October 16, 2023

**Re: Volcano Mesa Subdivision
Erosion and Sediment Control Plan
Engineer's Stamp Date: 6/27/2022 (C09E001H)**

# Temporary Erosion and Sediment Control Plan

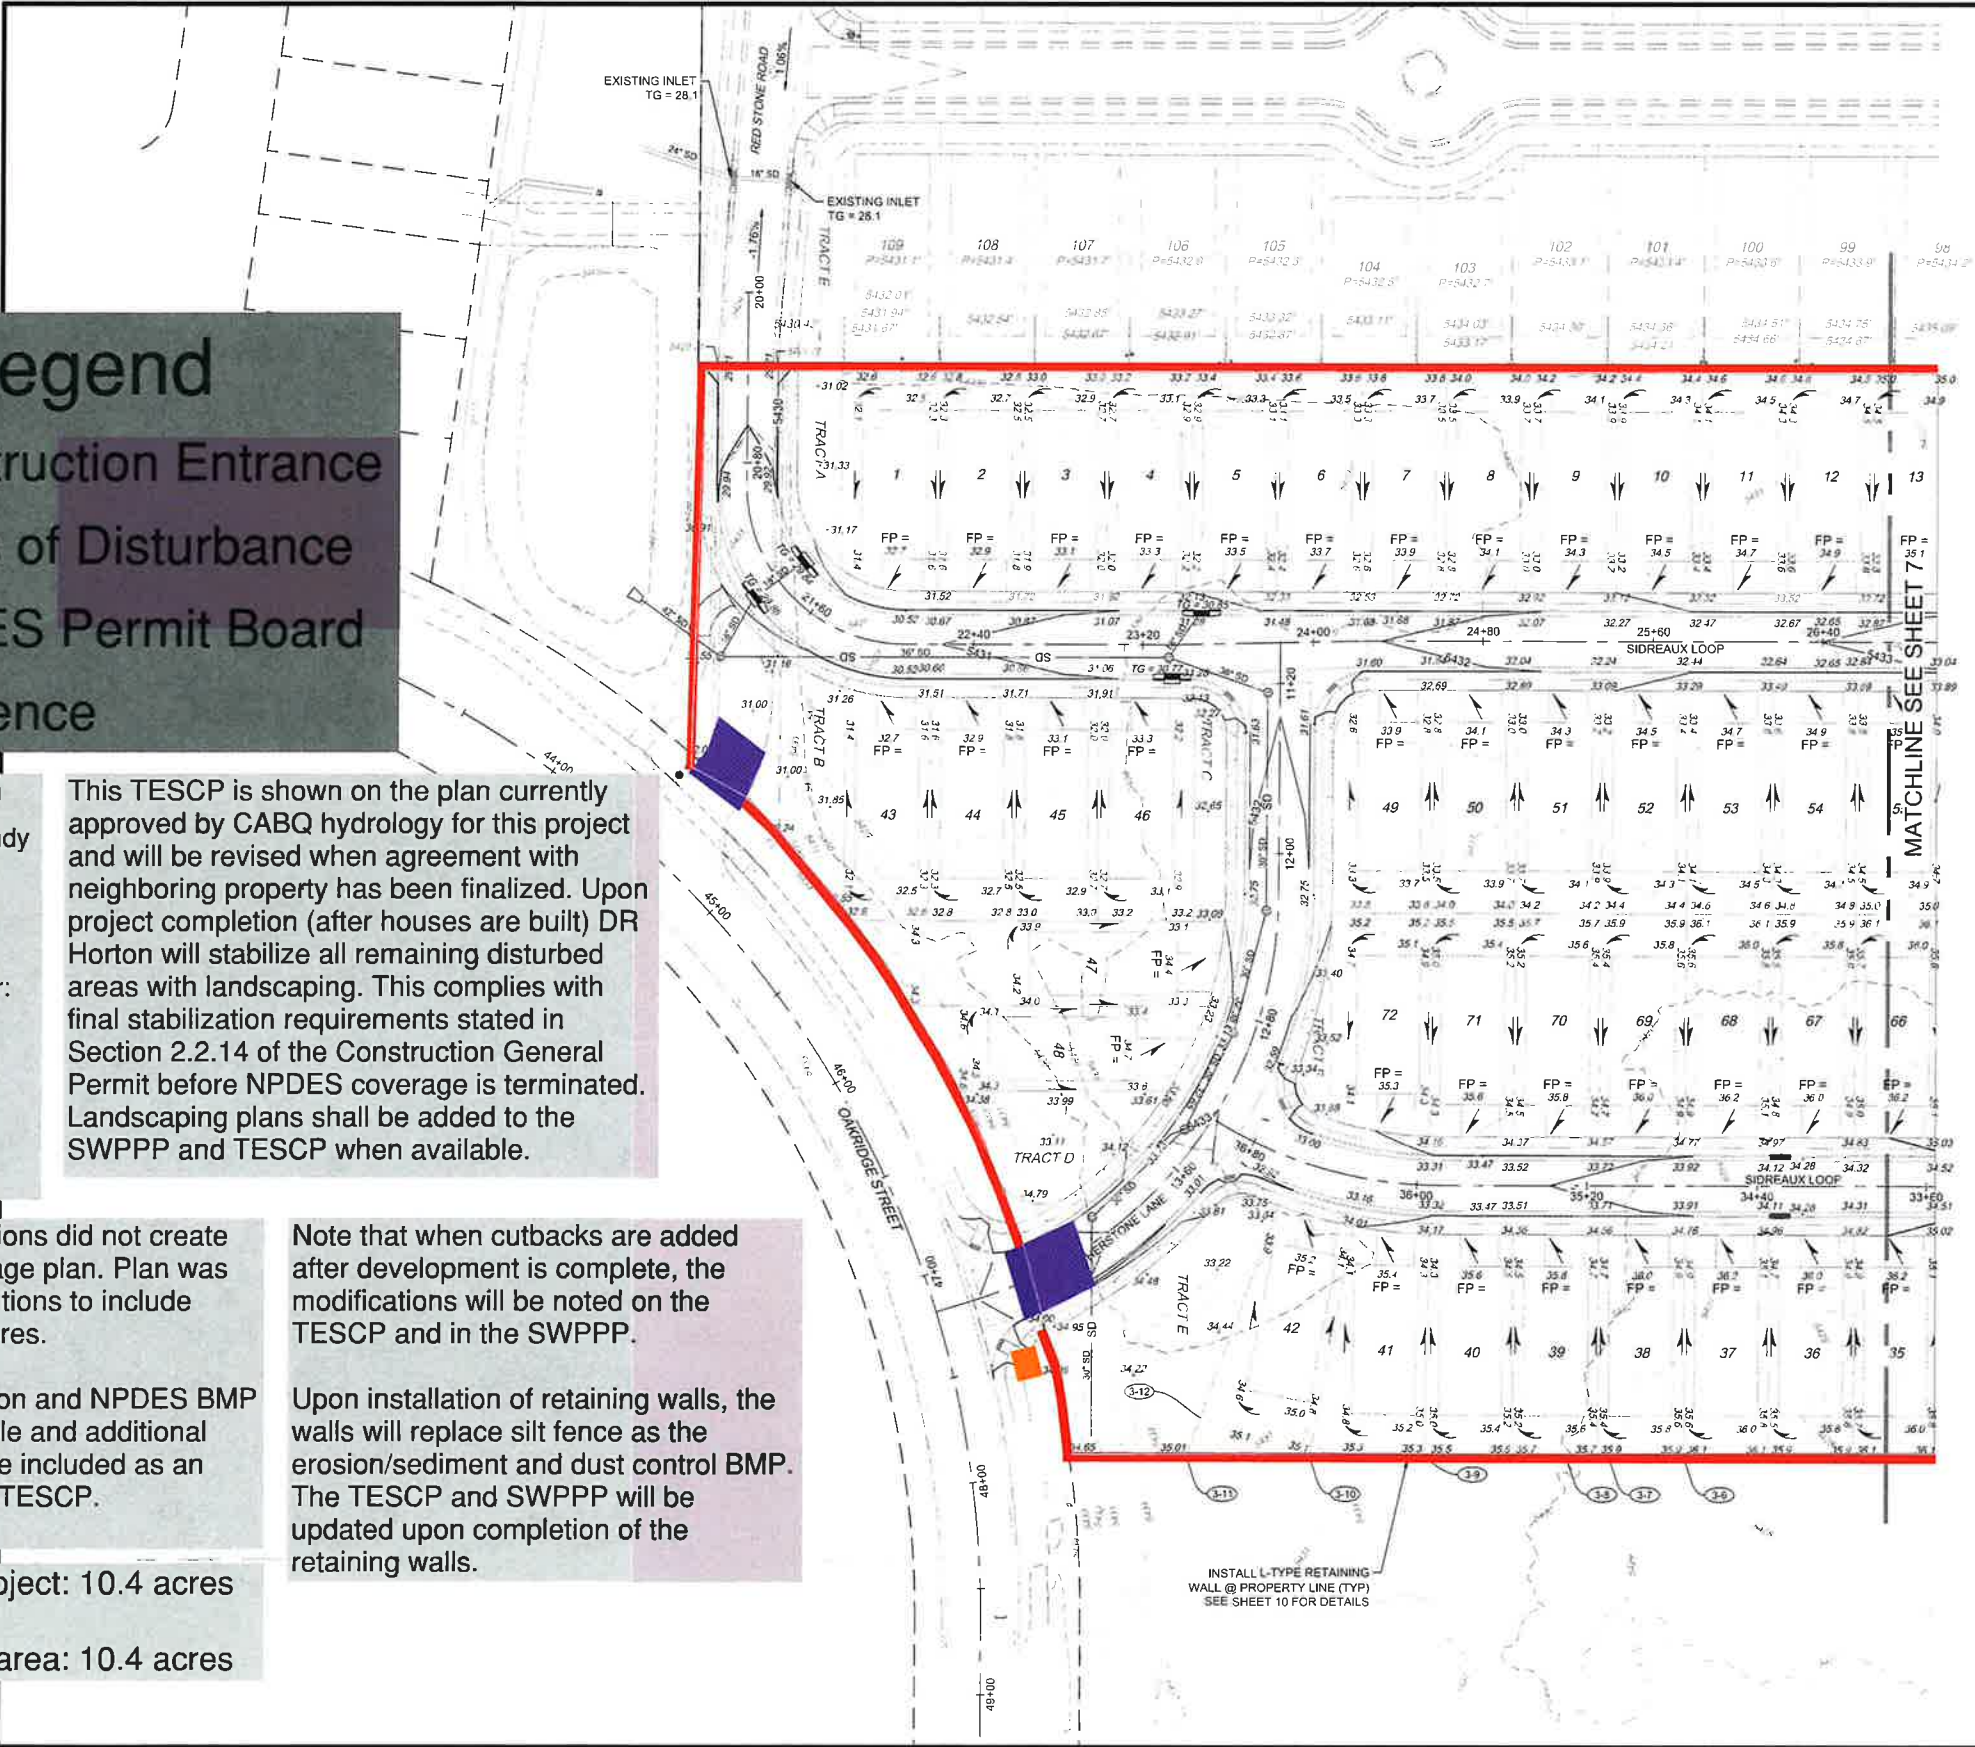
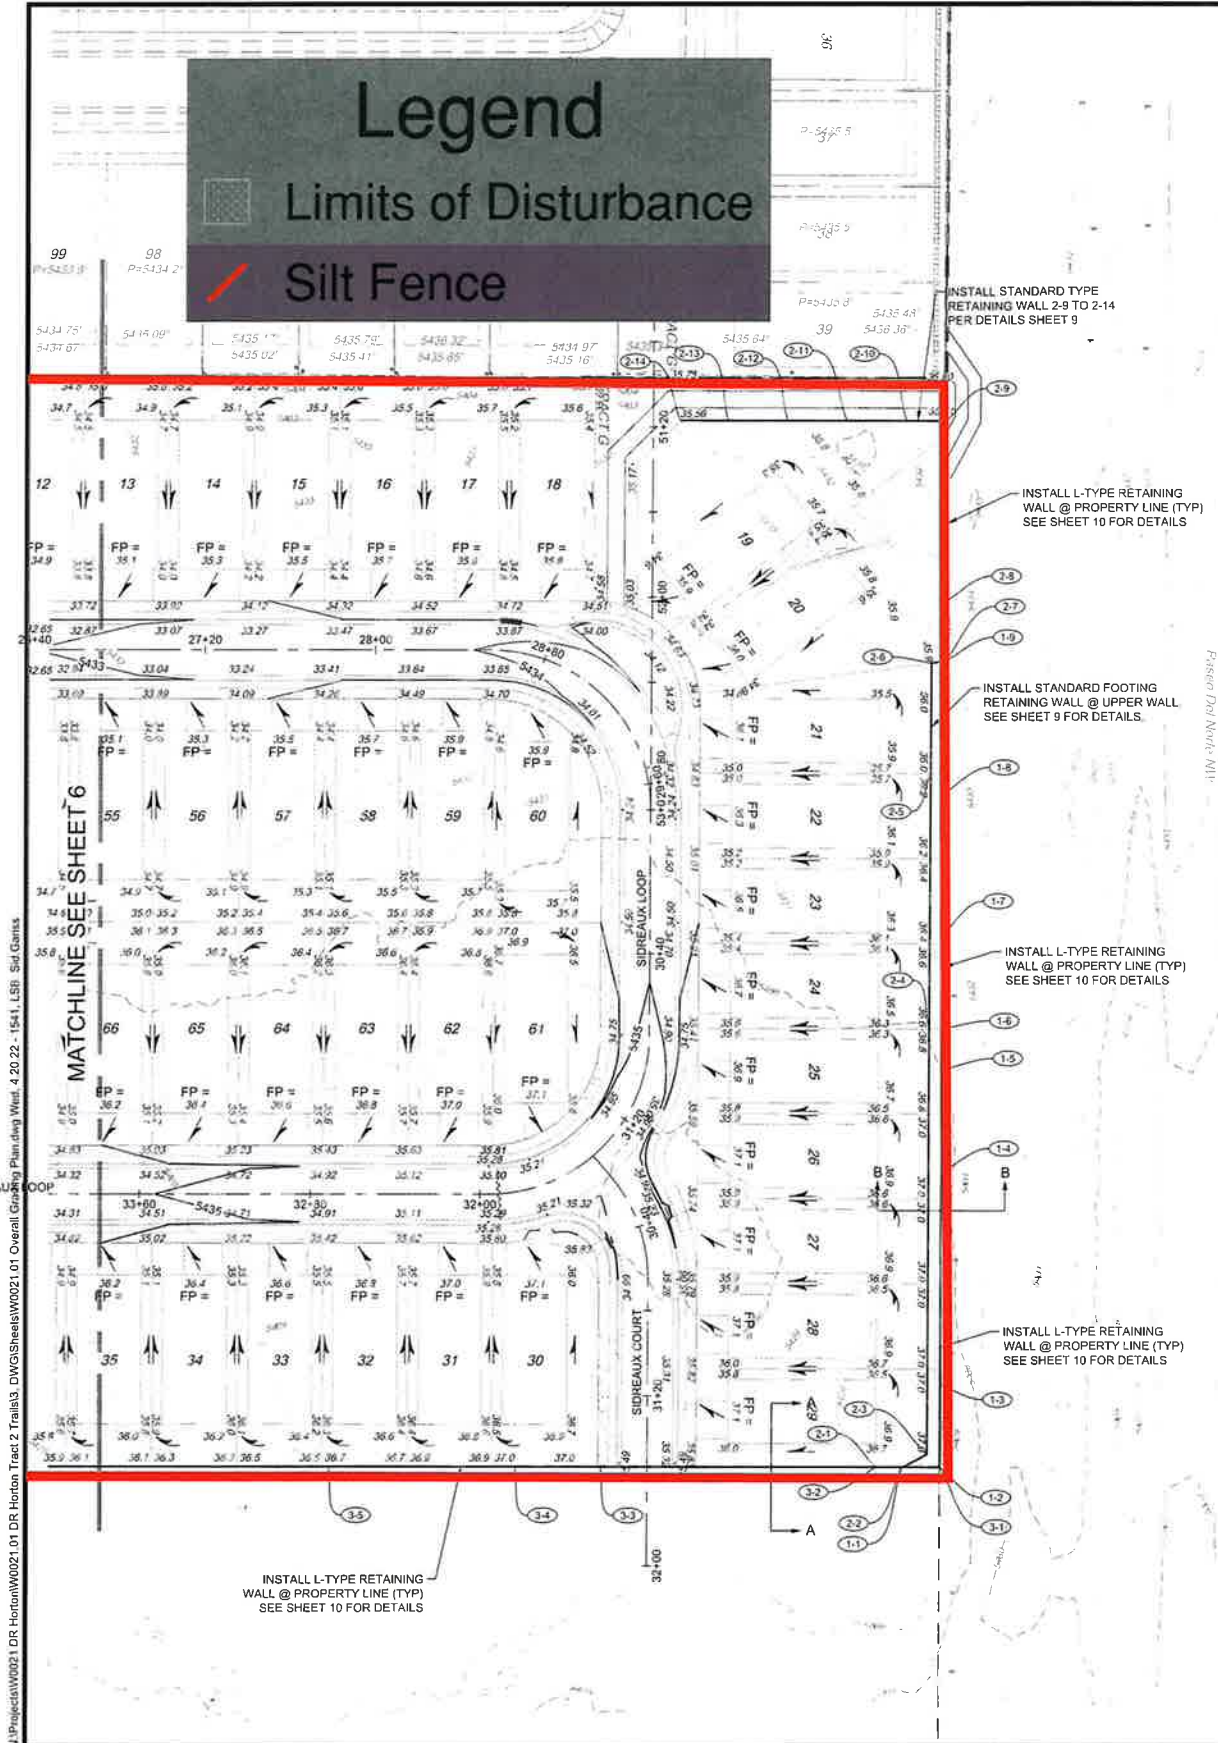
3. Several different ESC Plans have been submitted recently by Inspections Plus, including a modified version of the plan submitted by 814 Solutions on 6/28/22 with Kelly Fetter's PE stamp dated 6/27/2022, and another plan that doesn't have a professional stamp. These plans are inaccurate. They show Cut-Back Curbs where they are precluded by sidewalks and landscaping, so use a different control behind the sidewalk. They don't show the grading and land disturbance on Tract 3 east of DR Horton's site as shown on the attached G&D Plan approved by Hydrology on 12/12/2022. Use the approved G&D Plan (attached) to show the existing and proposed grades and the proposed erosion controls accurately.

4. The ESC Plan submitted includes an older version of the ESC Plan Standard Notes. Use the current ESC Plan Standard notes instead (attached).
5. Erosion control details of the Cut-back Curbs were missing and must be included.
